Development Facilitation Team (DFT) – Review Comments

Project No: PR-2024-009947 Date: 06-25-2025 Agenda Item: # 1 Zone Atlas Page: H-16

Request: Subdividing Lot 2-B of American Square into 6 lots. Requires public water, sewer and public sidewalk infrastructure.

Application For: MAJOR_PLT-2025-00007 – MAJOR PRELIMINARY PLAT

Preliminary Plat for Lots 2-A-1, 2-B-1, 2-B-2, 2-B-3, 2-B-4, 2-B-5 & 2-B-6, American Square Being Comprised of Lots 2-A and 2-B, American Square City of Albuquerque Bernalillo County, New Mexico May 2025

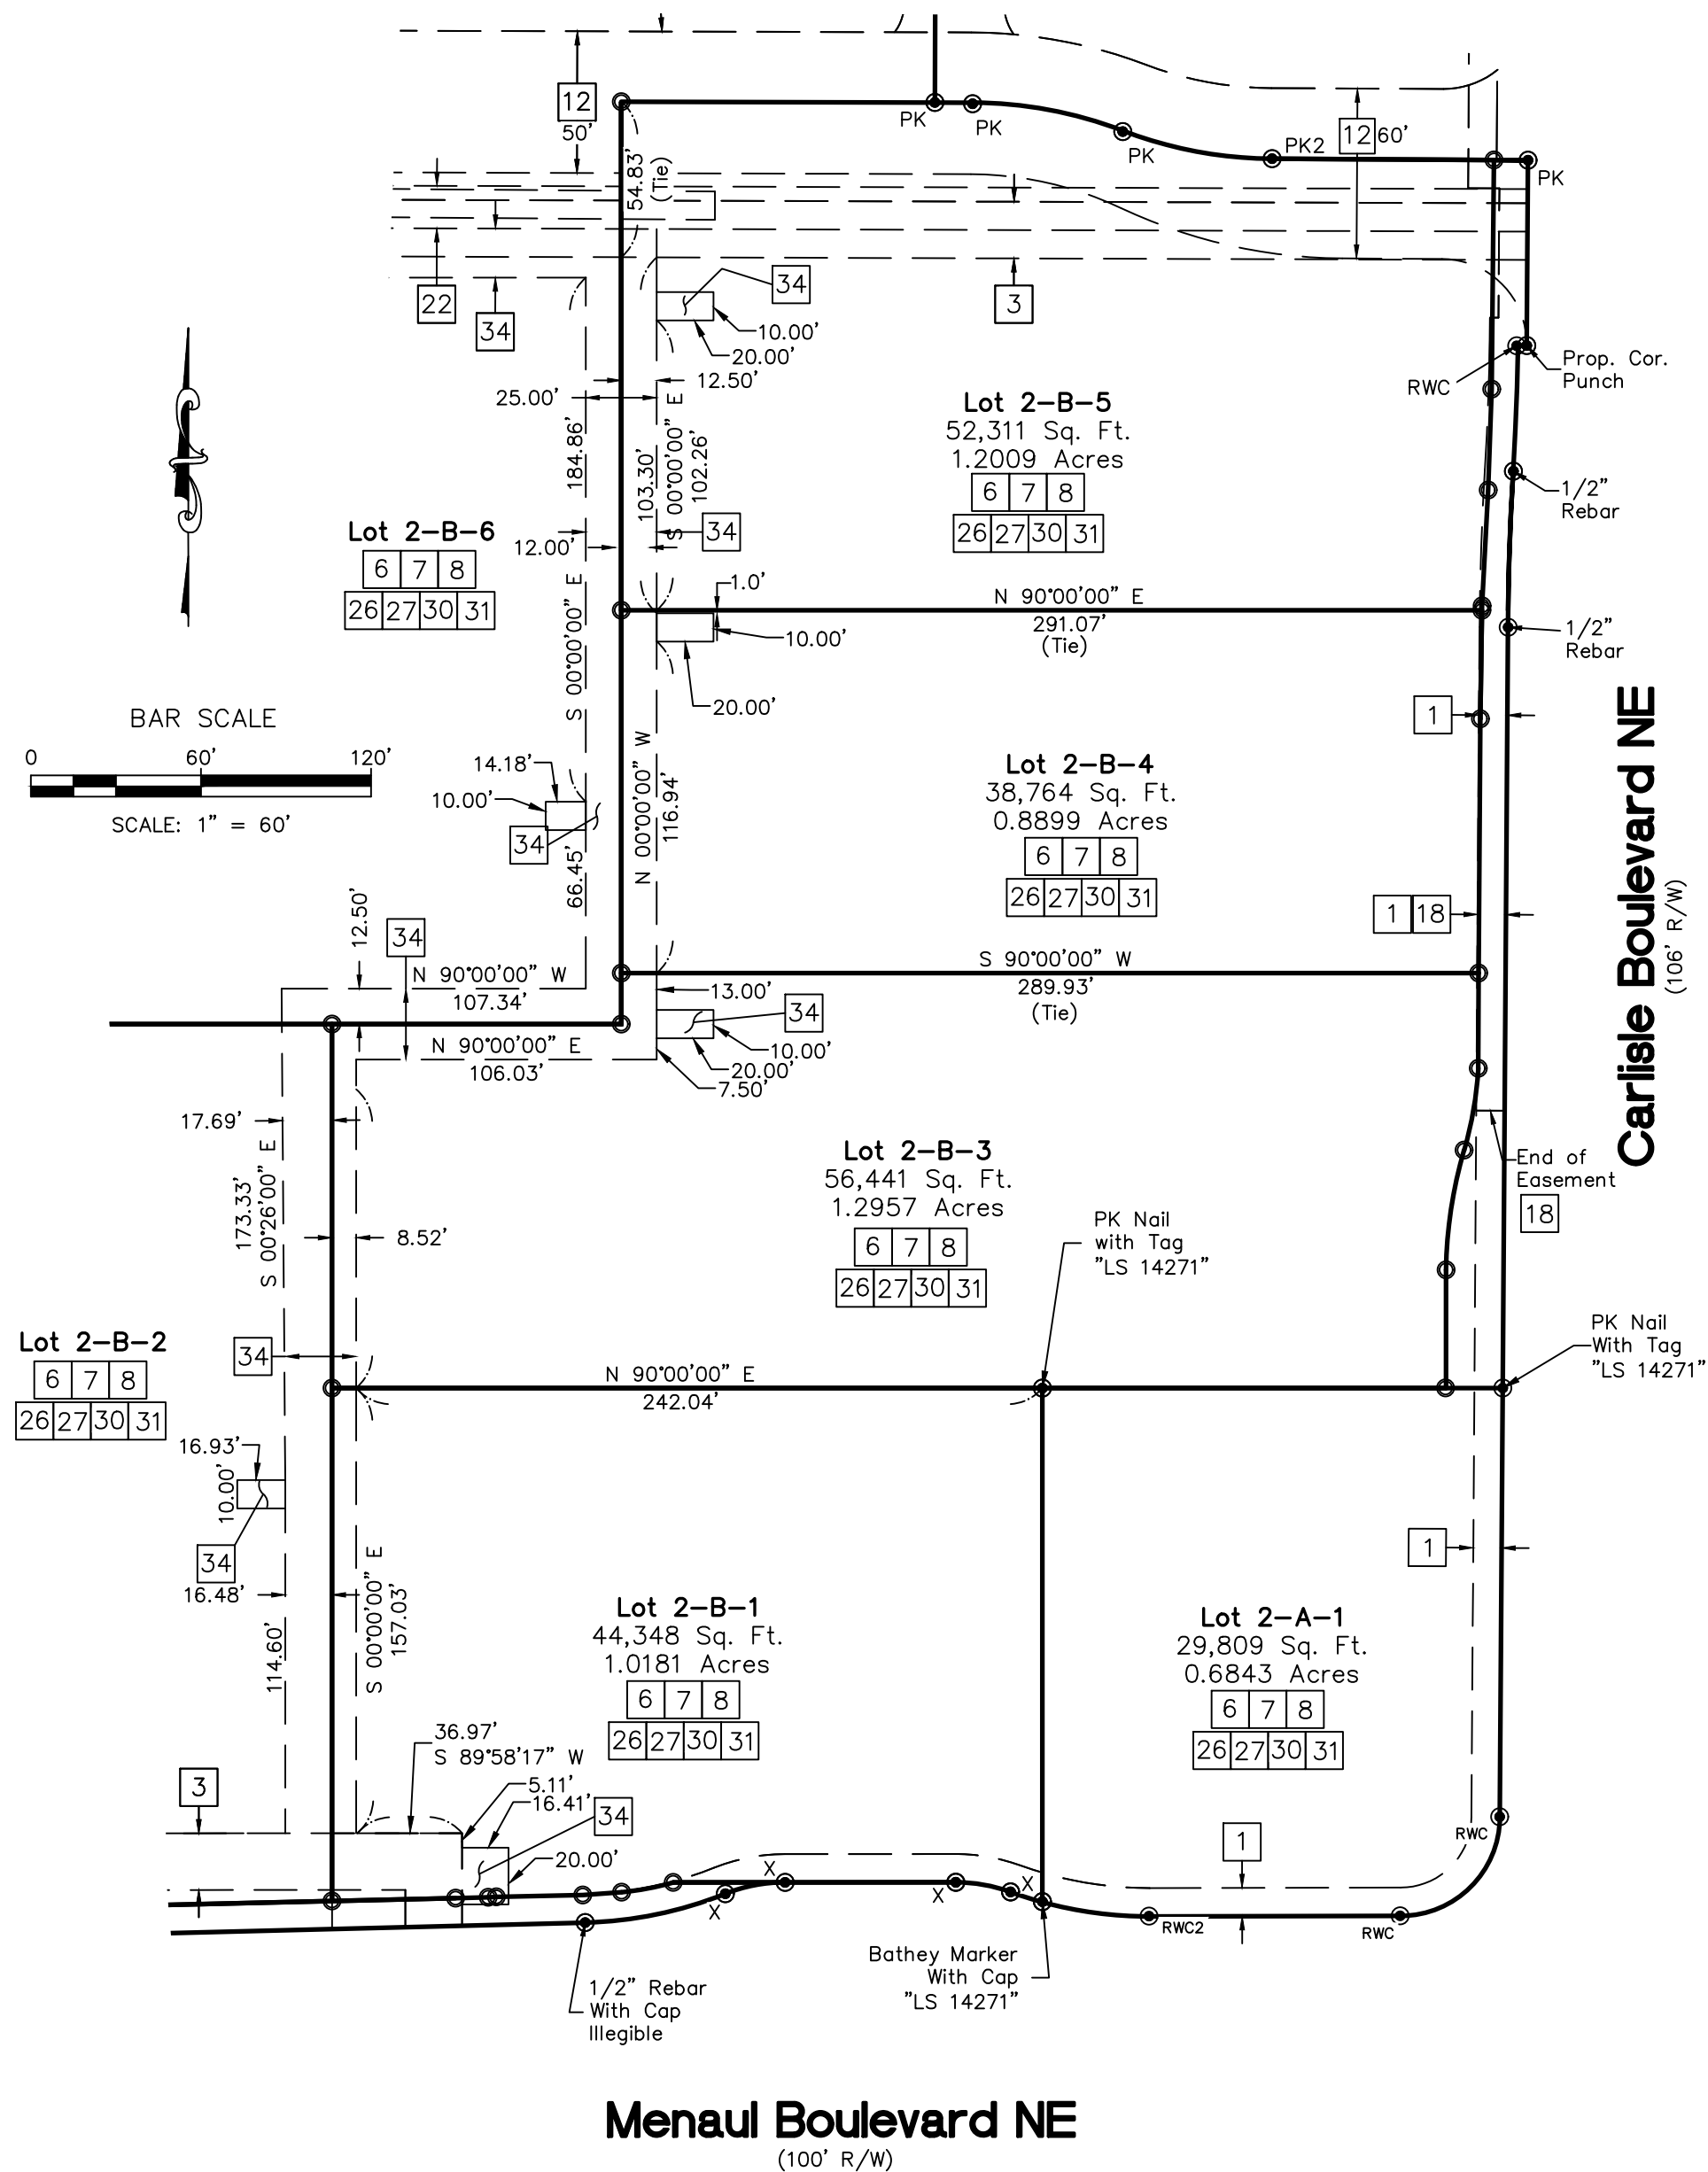
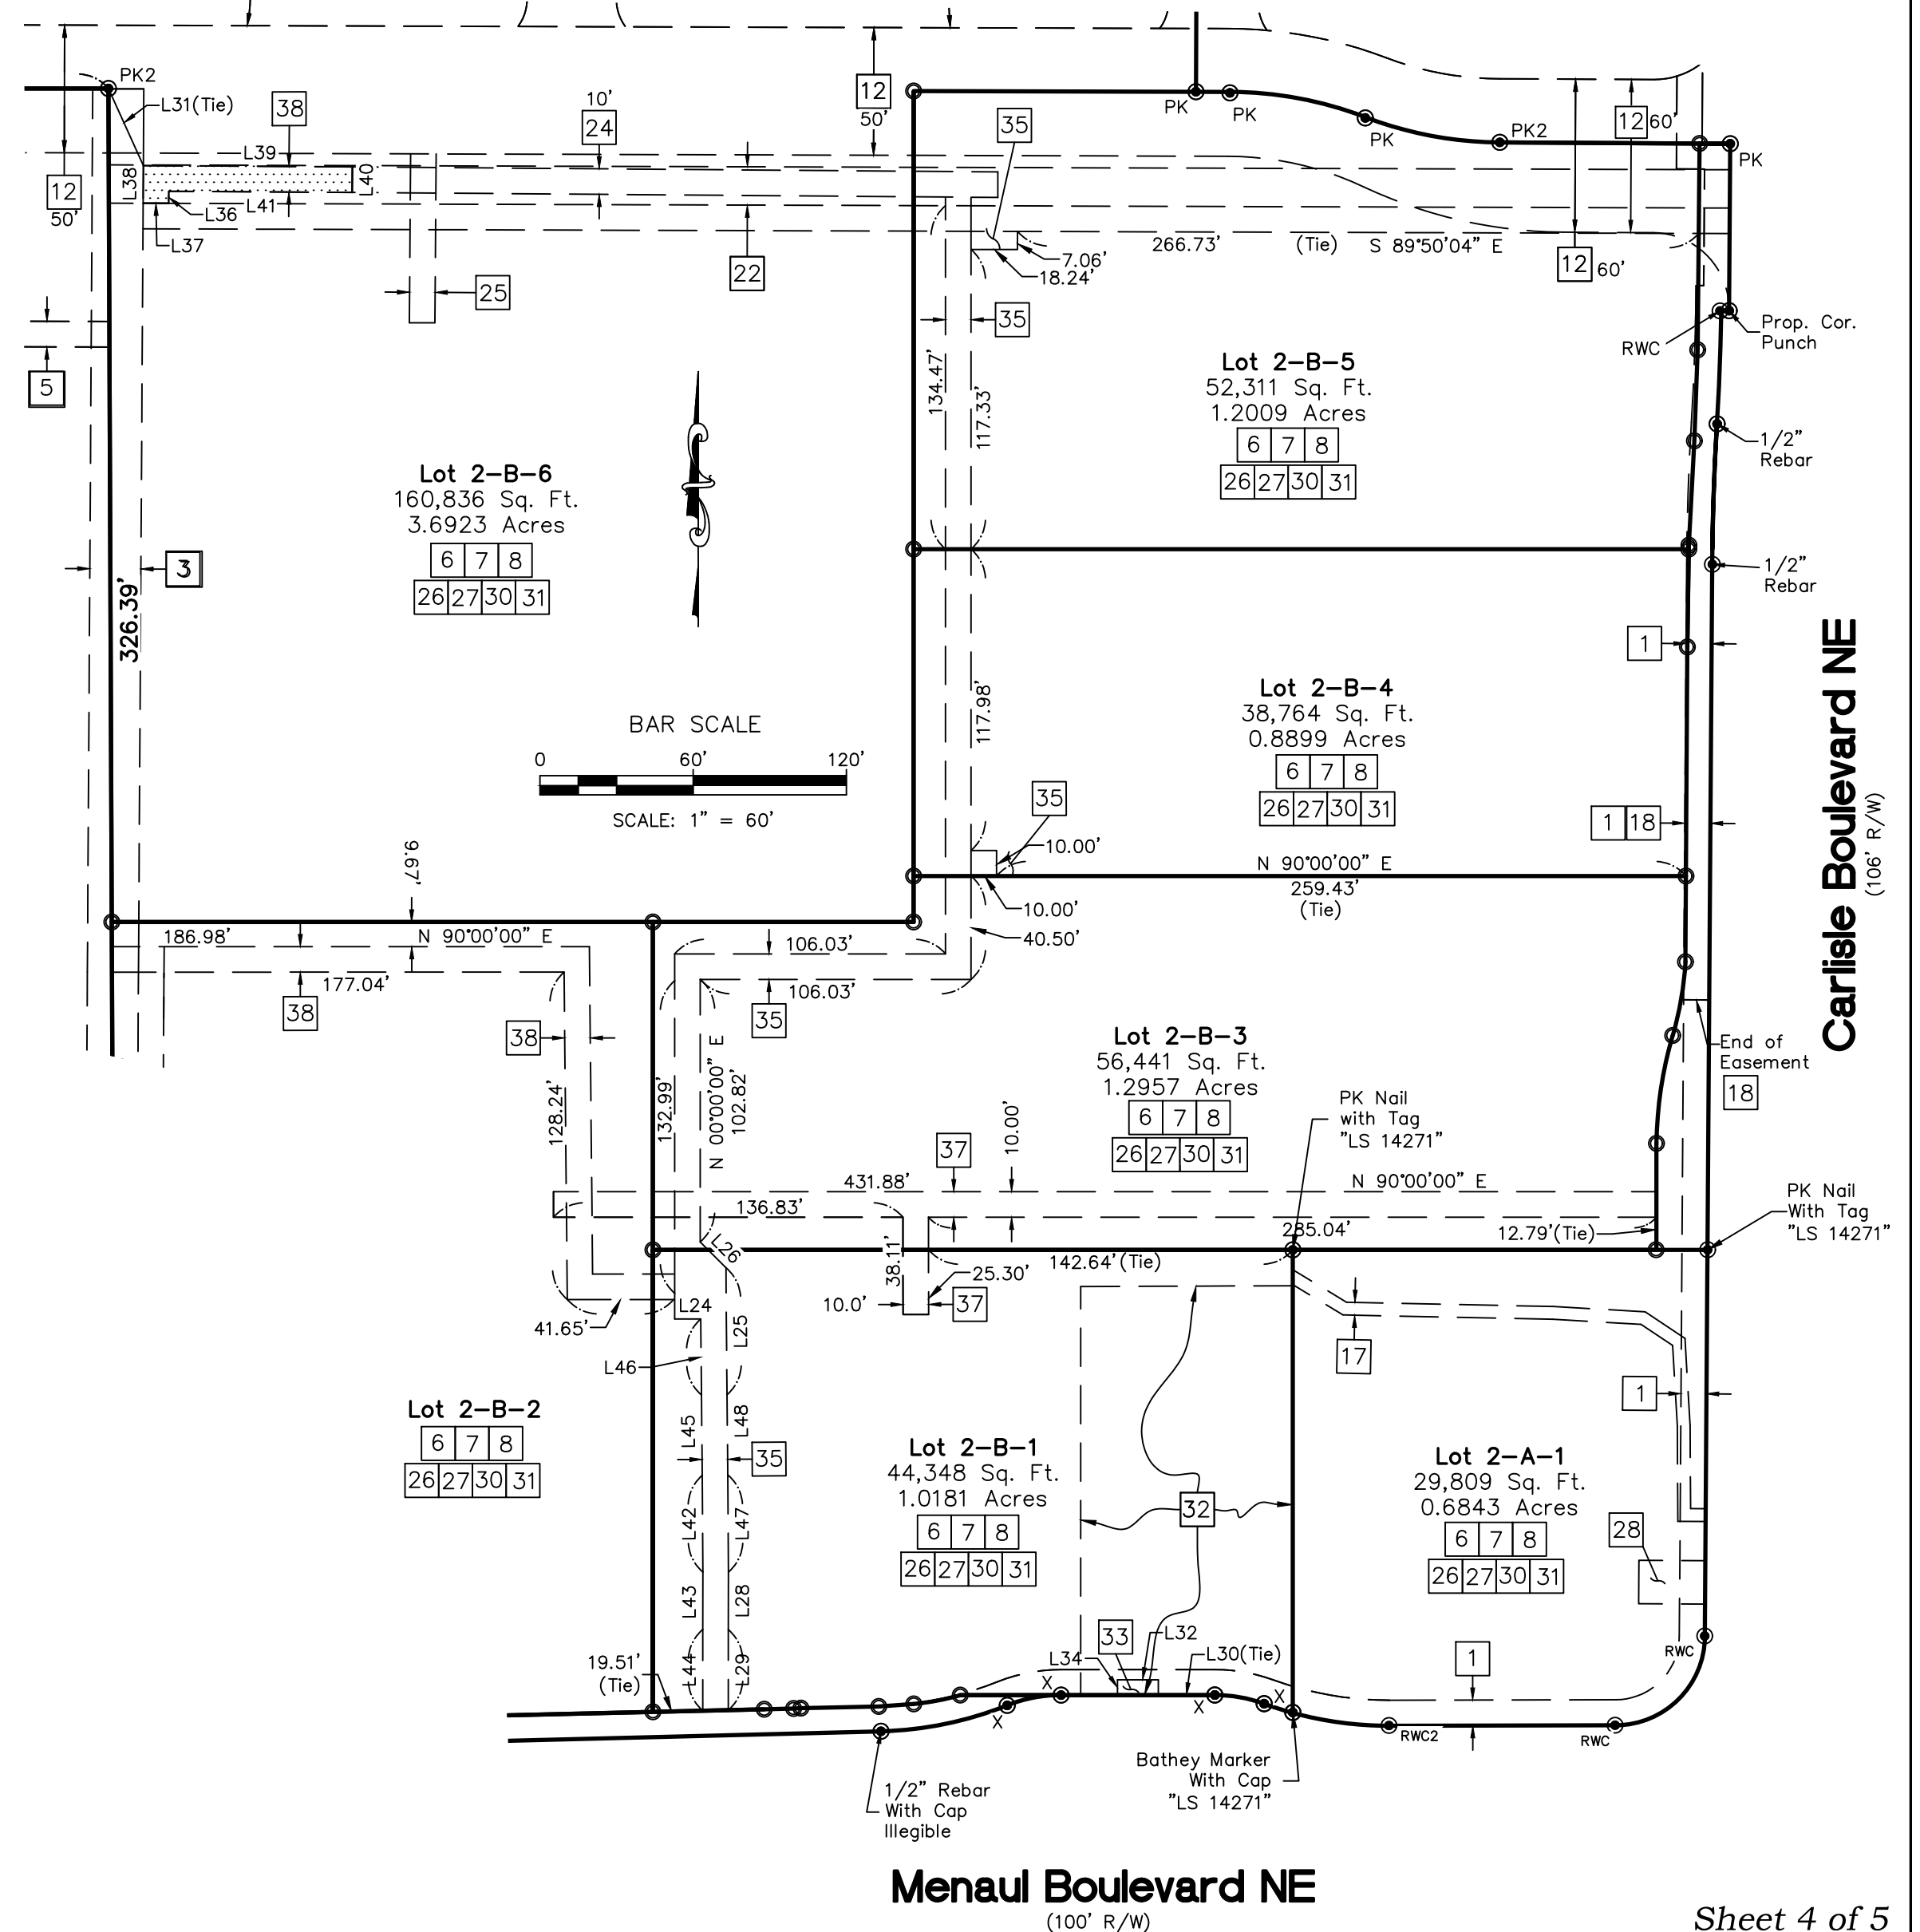
1. Availability Statement 240702 provides conditions for service.
2. The language for easement 34 states it is a 25 ft public water and sanitary sewer easement however it is also called out for 10 feet bump out easements for what to appear to be potentially fire hydrants or meters. Please clarify how this will be handled to make a clear delineation.
3. Infrastructure List:
 - a. Please note location of public water and public sanitary sewer to also state within proposed public water and public sanitary sewer easement.
